proposal to build a ground floor
extension at 1, David's Close, Bognor Regis

Ground floor extension (re-submission following BE/36/10/)
1 David's Close Bognor Regis

Planning Application BE/52/11
Proposed extensions at 1 Davids Close, Bersted

Elevations of Proposed Alterations to House at 1 Davids Close
Bognor Regis PO21 5TR for Mr.& Mrs E.Soothill

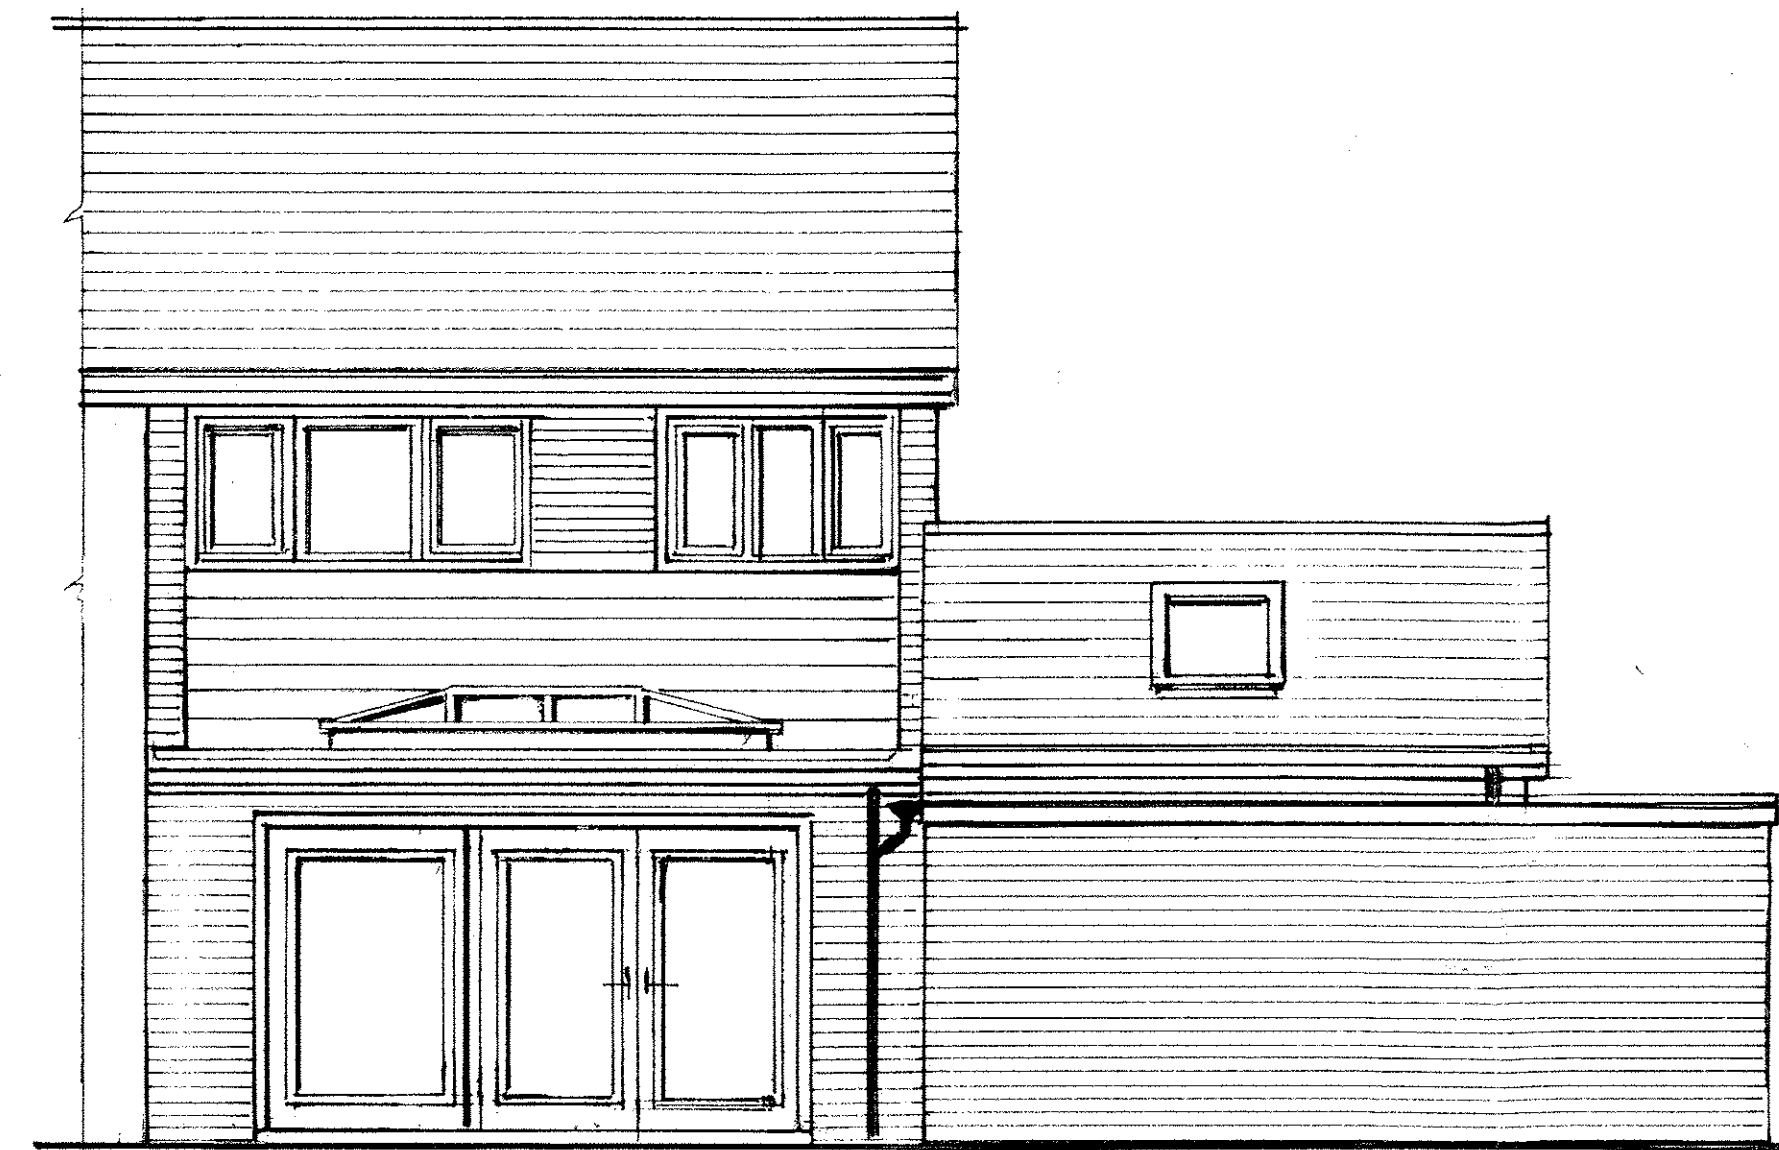
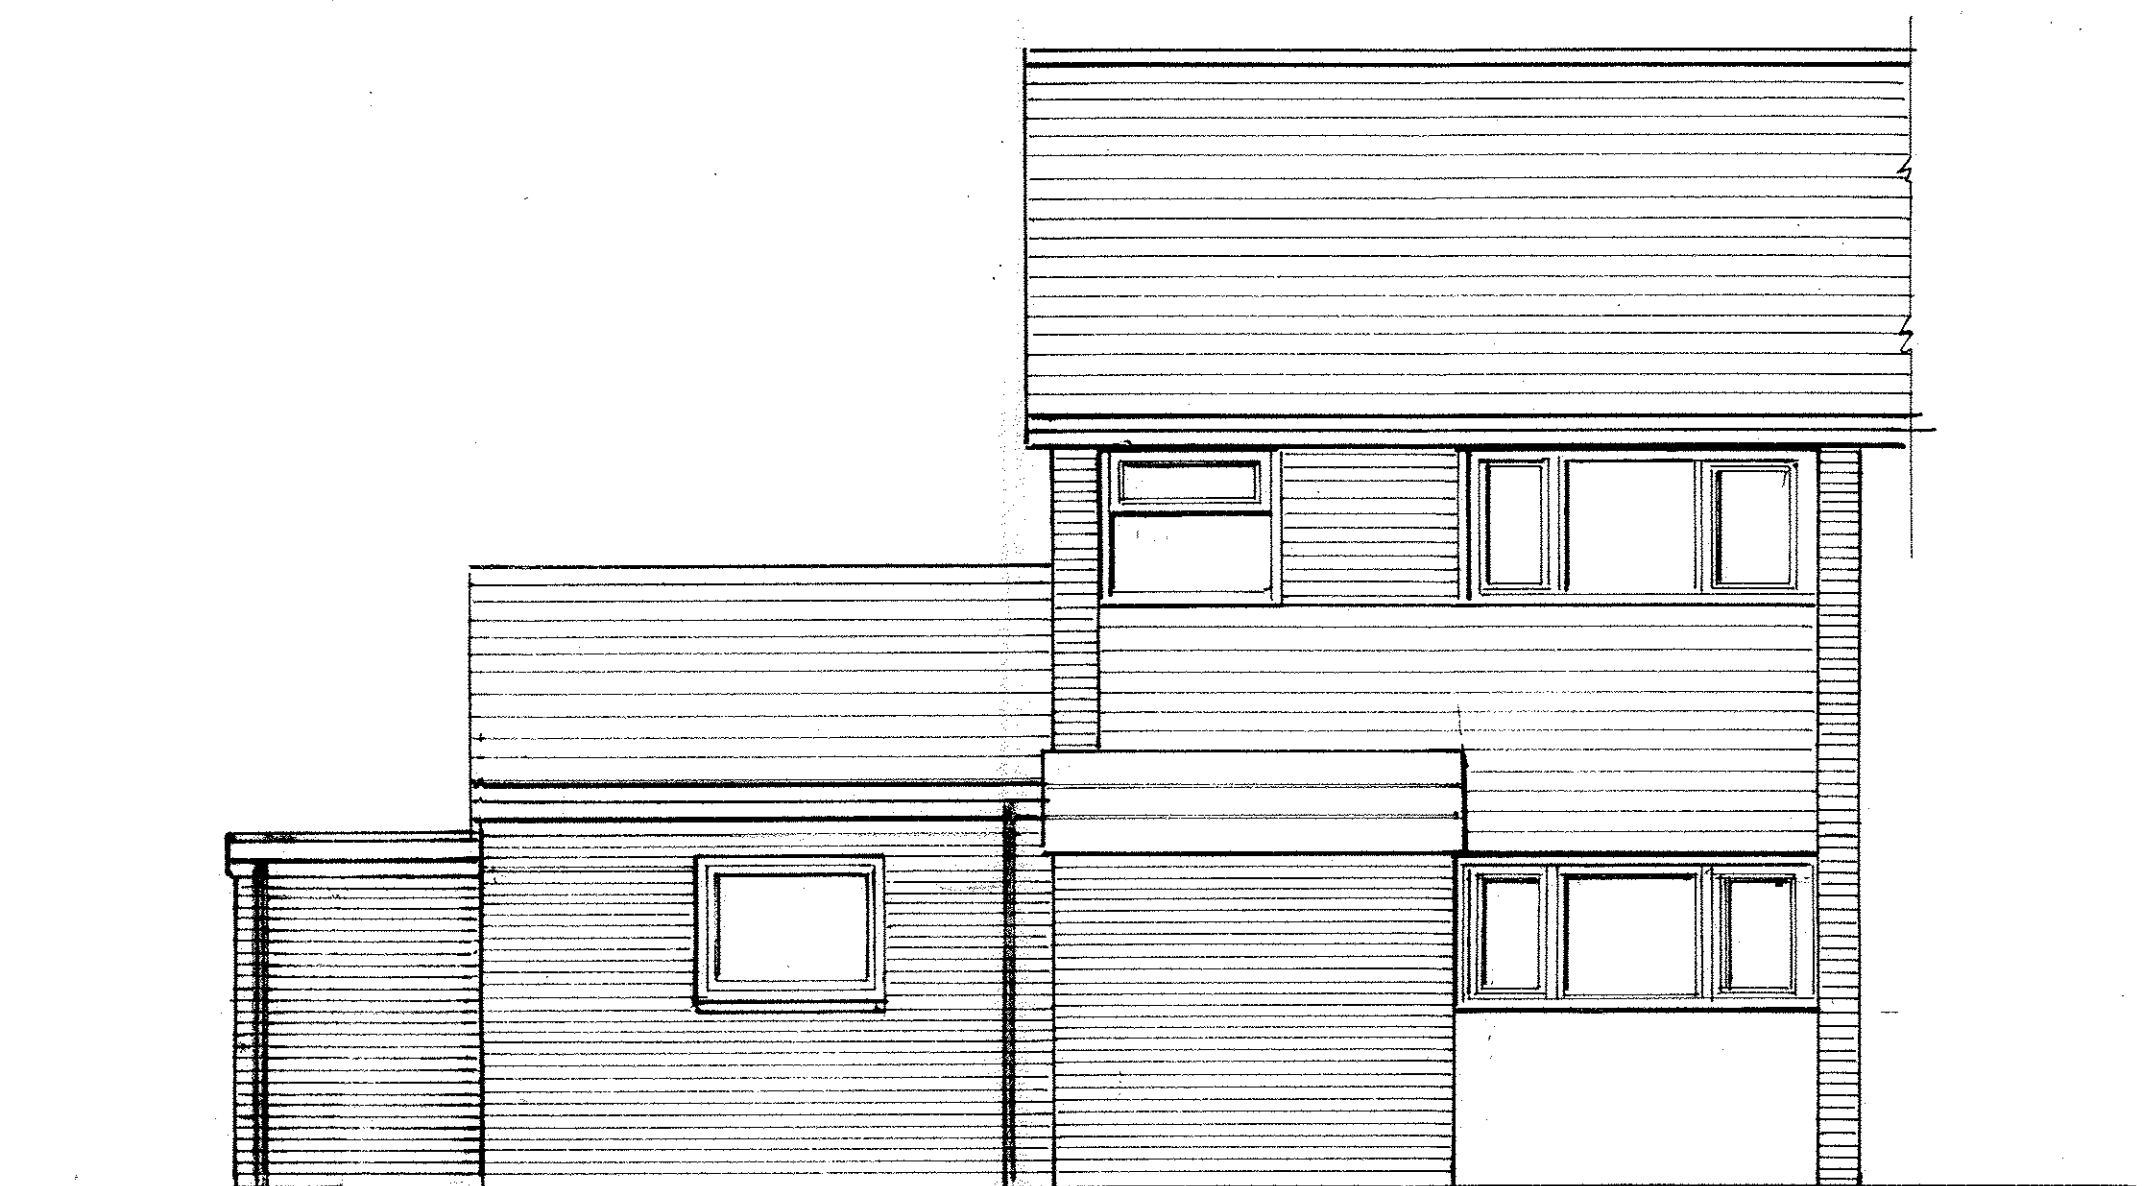
Aesthetically, the pitched roof of the dining room extension with it's roof light will be out of character, especially being next to a flat roofed garage and 'shed'. I would also question the wisdom of providing direct access to the garage from the house.
